Our Reference : F2006/00713
9 July 2018

Re : Notification of Modification Request Orora Paper Mill, Matraville (MP05_0120 (Mod 8))

- Section 4.55 (1A) modification to provide for staged demolition of the existing B7 Reel Store building and extension of the existing noise barrier along the north-eastern boundary of the site.

MILL WIDE
B7 BOUNDARY
STAGE 1 NOISE BARRIER
EXTENSION

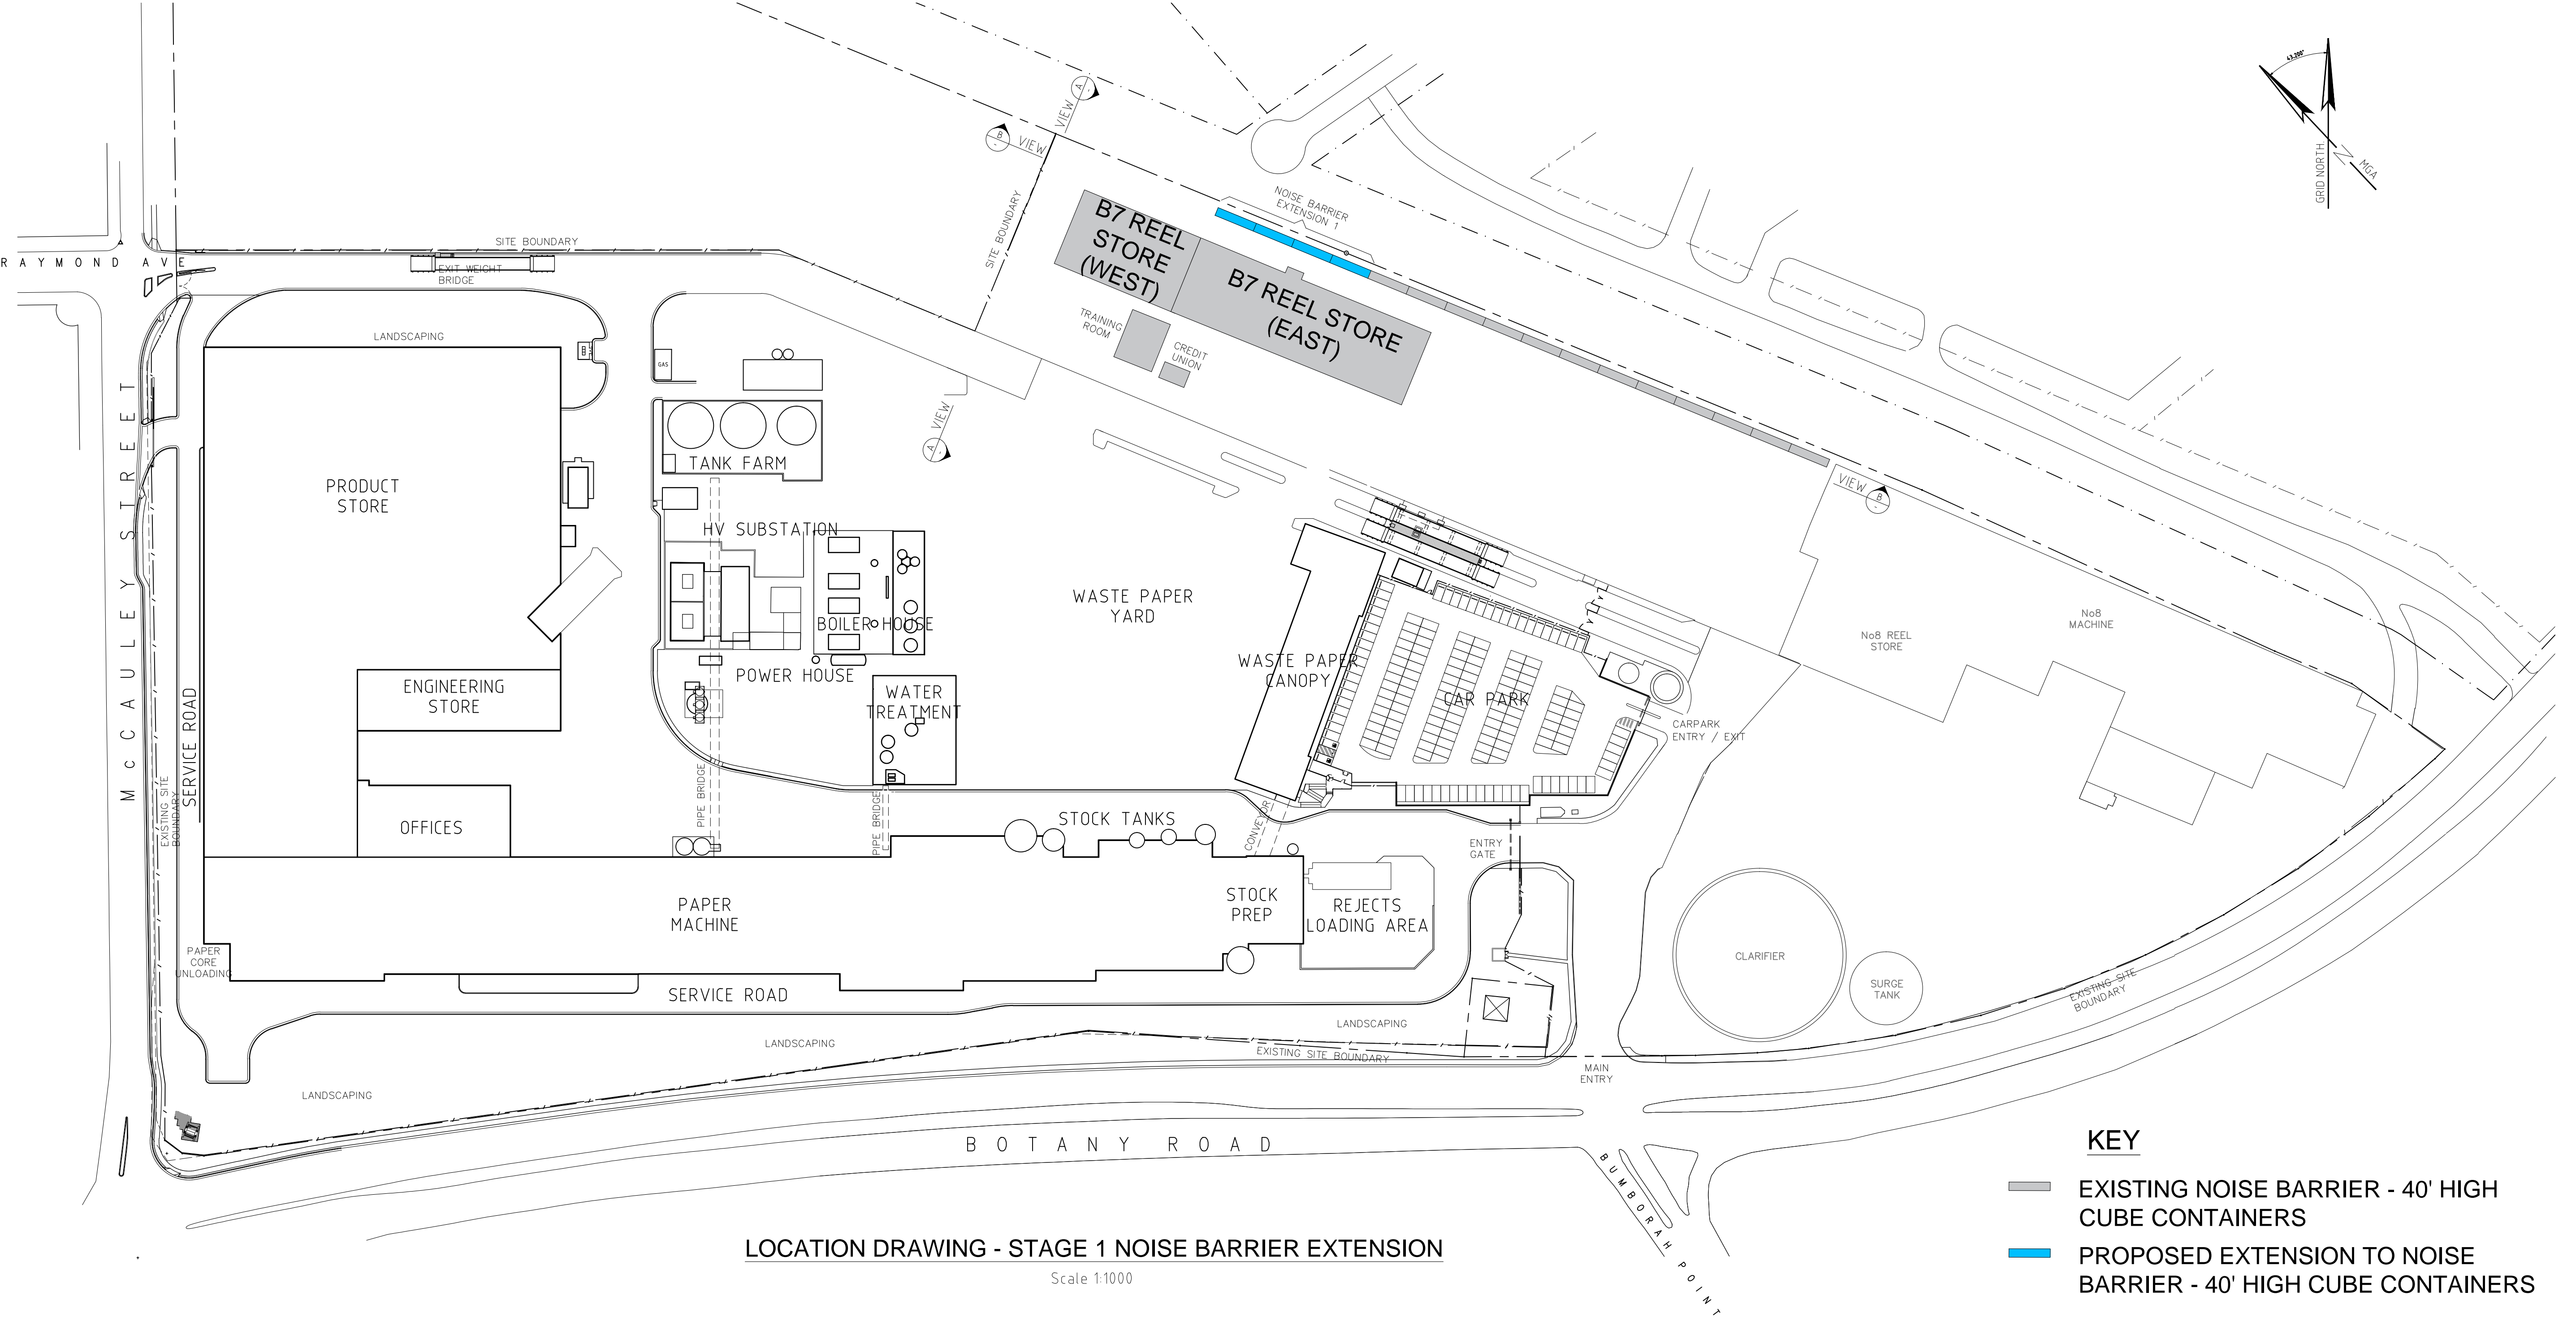
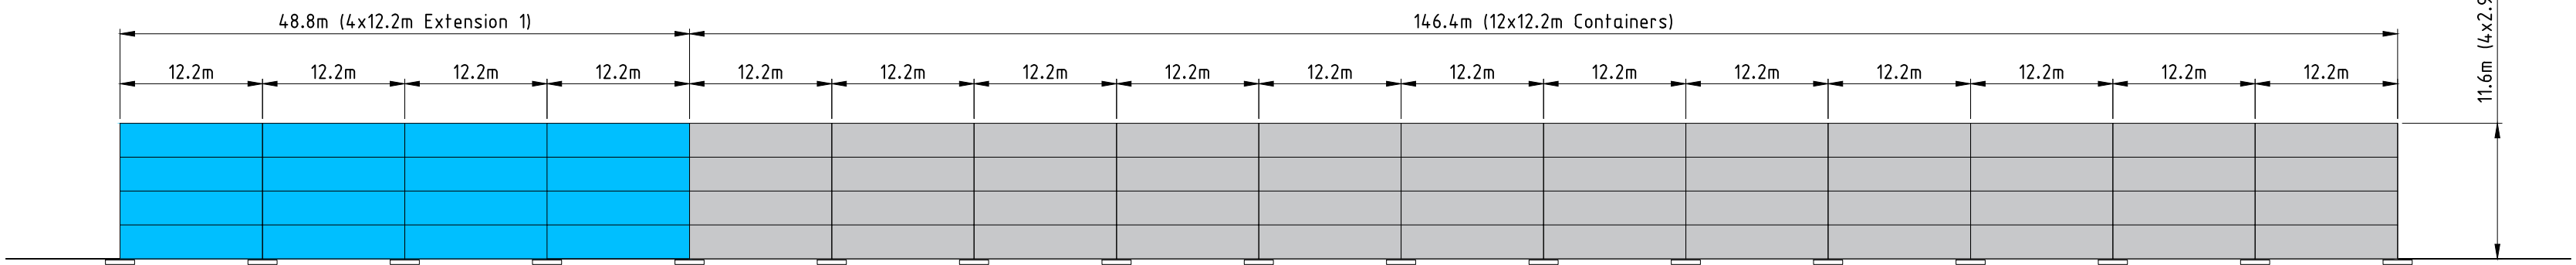
Council notes the proponent's argument that the justification for extending the noise wall following demolition of the B7 Reel Store building, and not before, is due to "space constraints". Council contends that this justification is questionable as the permanent noise wall approved under Modification 2 has a smaller footprint comprising a hebel structure with a width thickness of 150mm compared with the container barrier thickness of 2400mm.

Council asserts that the smaller nature of the permanent hebel noise barrier wall would allow it to be installed adjacent to the B7 Reel Store prior to its demolition so that it would be in place during and after the demolition of the B7 Reel Store building. This would also minimise any noise, dust or vibration impacts on neighbouring residential properties. This option is seen as preferable to the current proposal which would permit two thirds of the B7 reel storage building to be demolished before even the first half of the temporary noise barrier could be installed which Council understands would leave Orora in breach of their noise licensing requirements.

In summary, while Council supports the need to extend the existing temporary noise barrier to mitigate the noise impacts of the B7 Reel Store demolition, Council maintains that a permanent noise wall should first be installed in the location of the previously demolished Building B7 as per condition 10A approved in 2010 as part of modification 2 to the consent.
